**Subject:** 2025/92968 at location 29, Huddersfield Road, Mirfield, WF14 8AE

Please see ecological commentary below.

Figure 3: Building B, The hall house.

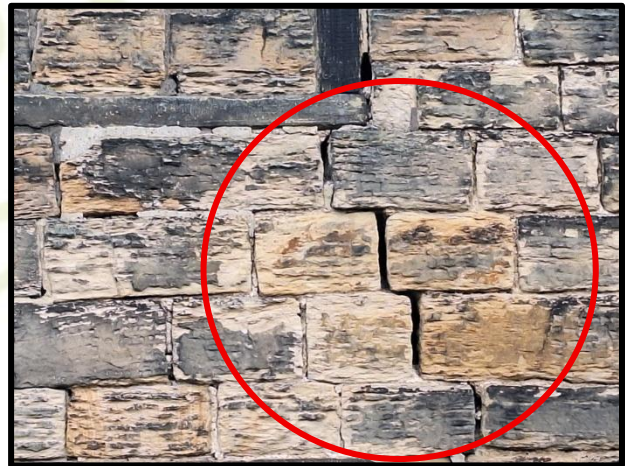
- Building A, the converted stable, has **low** (1no presence/absence surveys required) roost suitability and Building B, Hall house, has **moderate** (2no presence/absence surveys required) roost suitability. These surveys will need to be completed during optimal bat survey season (April -August) and must be conducted prior to determination. This cannot be conditioned predetermination due to planning guidance and Case Law (CO/2820/2008 / 2009 EWHC 1227(Admin)). Further conditions will be provided following this.

Bats – Presence / absence surveys (1no for Building A and 2no for Building B) to be provided prior to determination to understand whether roosts are present and if an EPS bat licence is required.
